September 22, 2022

Thank you for this opportunity to provide comments. Following are the Environmental Public Health comments on the CU-22-00003, Brethren Frontier School, notice of application. The applicant must provide current, satisfactory bacteriological and nitrate test results on the water system to the Kittitas County Public Health Department.

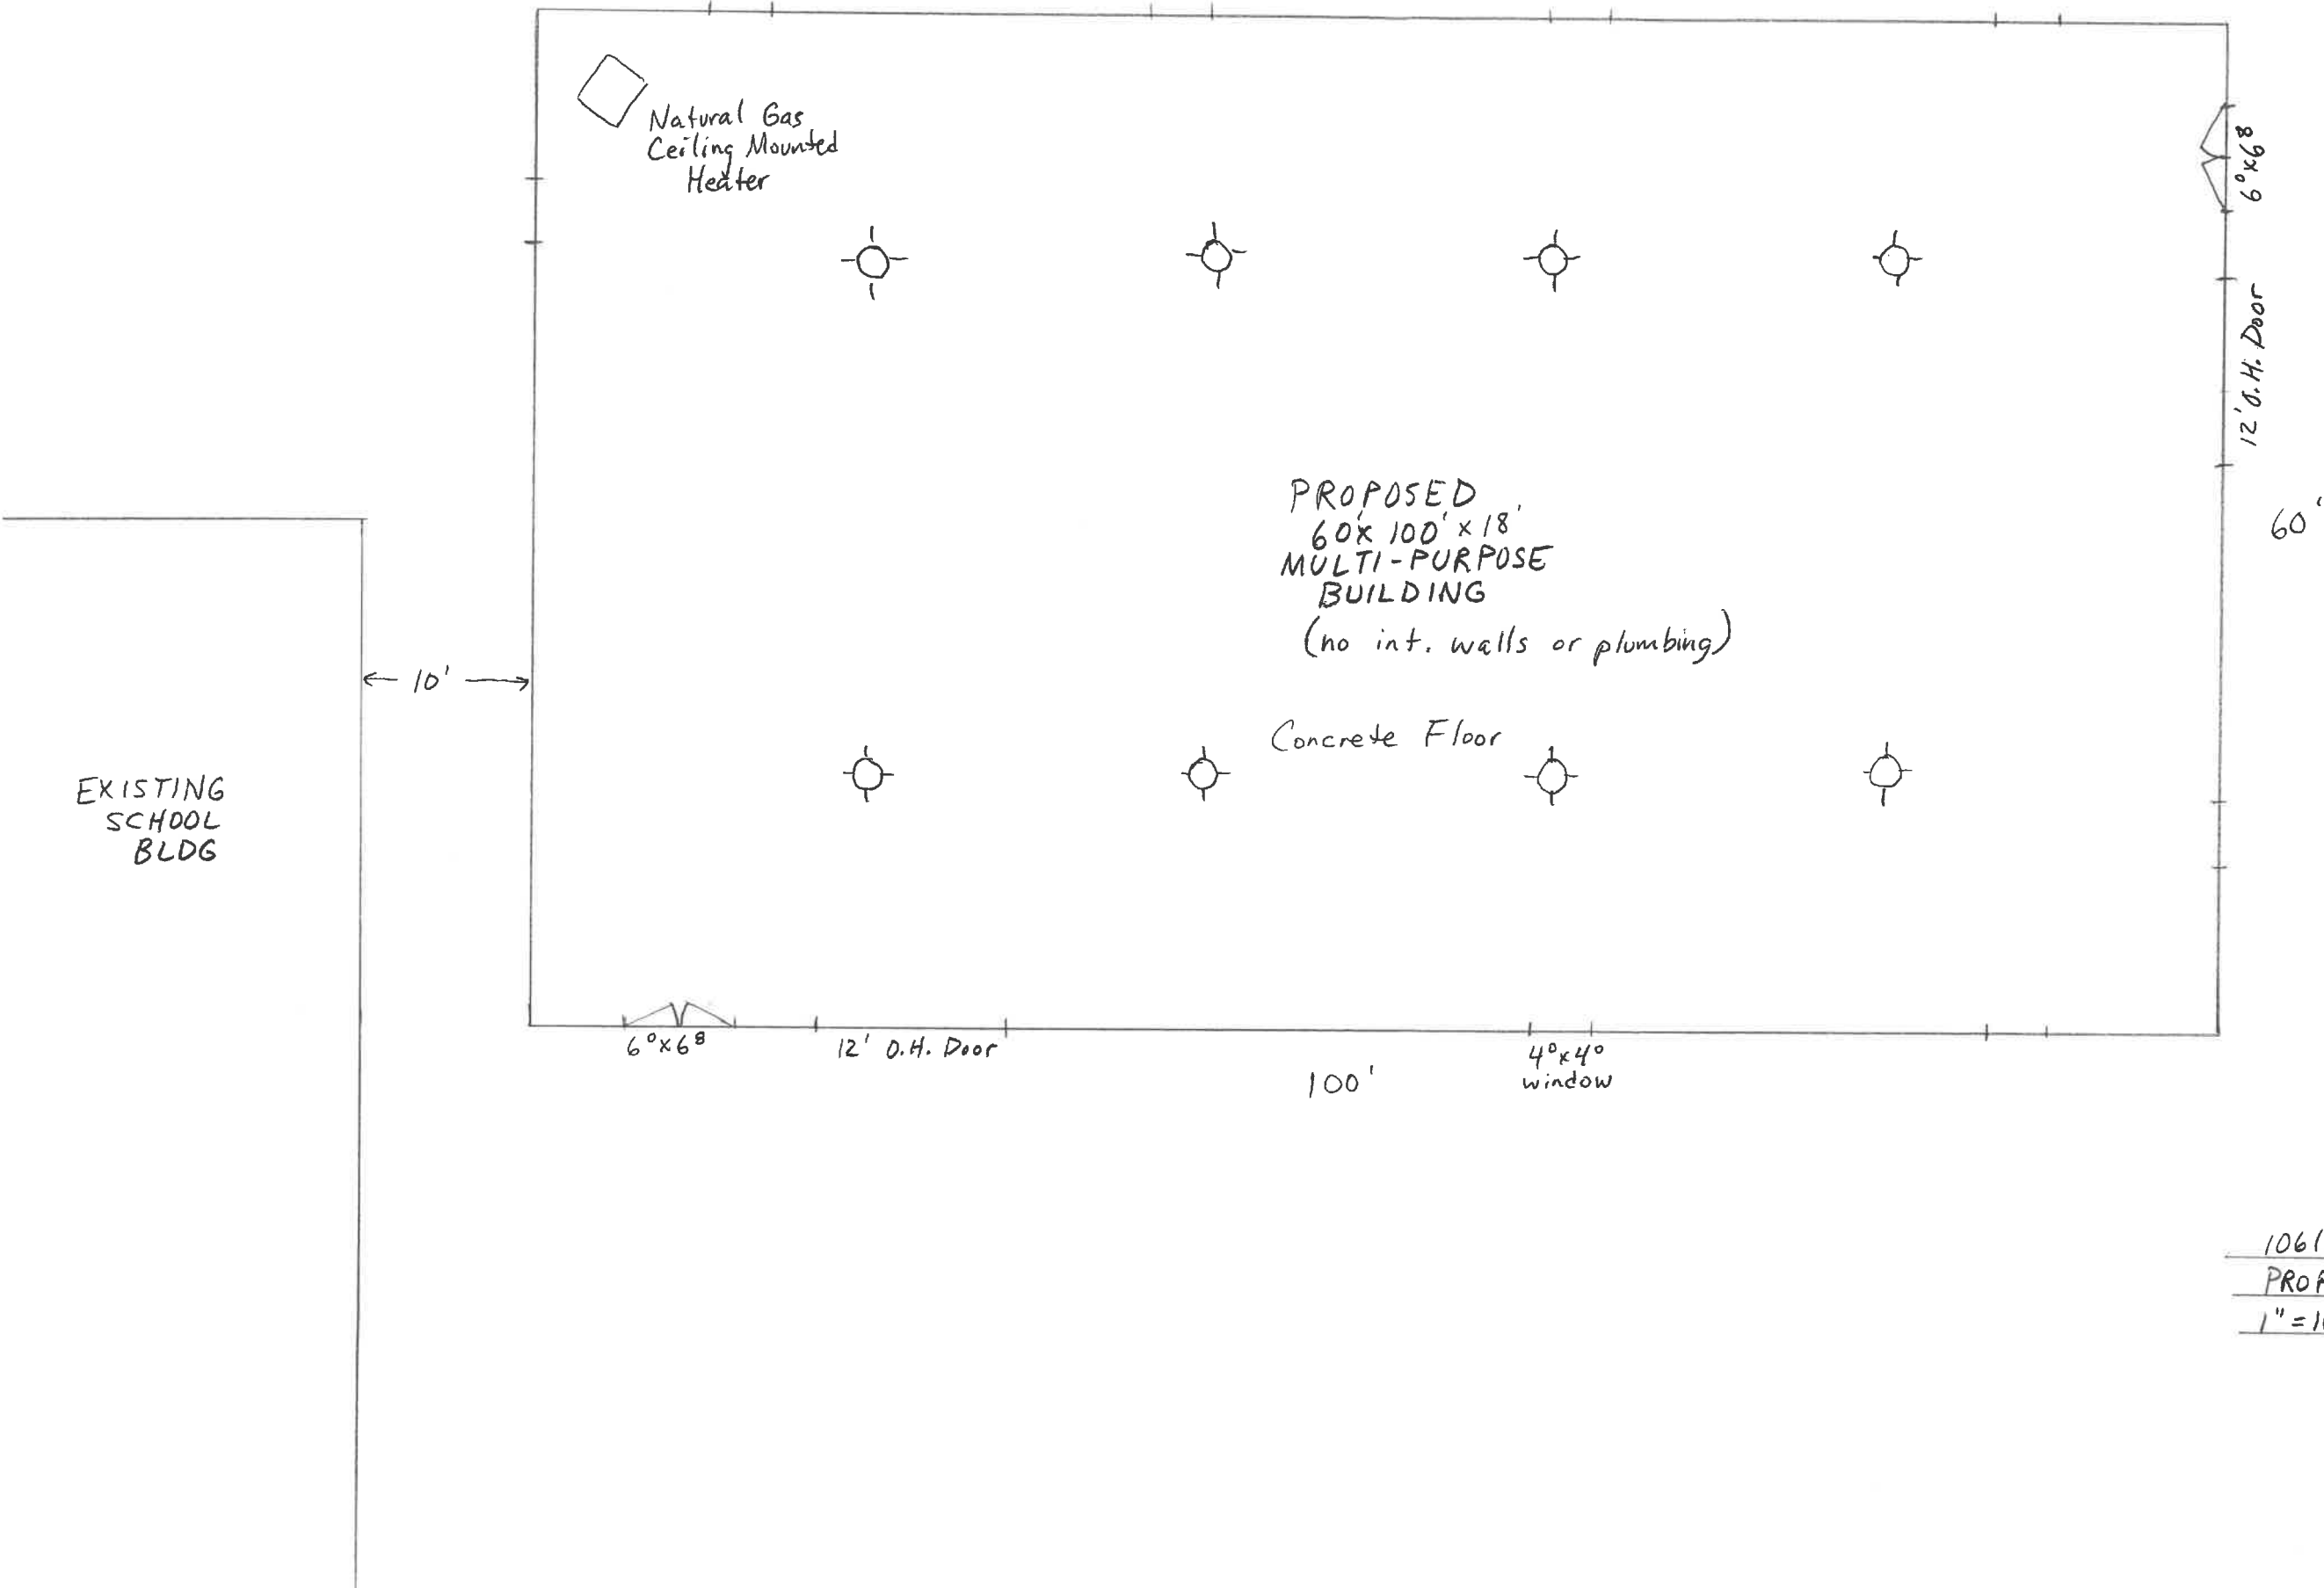
According to the site plan provided in the application materials for the project, it appears that the current drainfield for the school is being driven over and parked on. This issue needs to be addressed as the applicants move forward with their project.
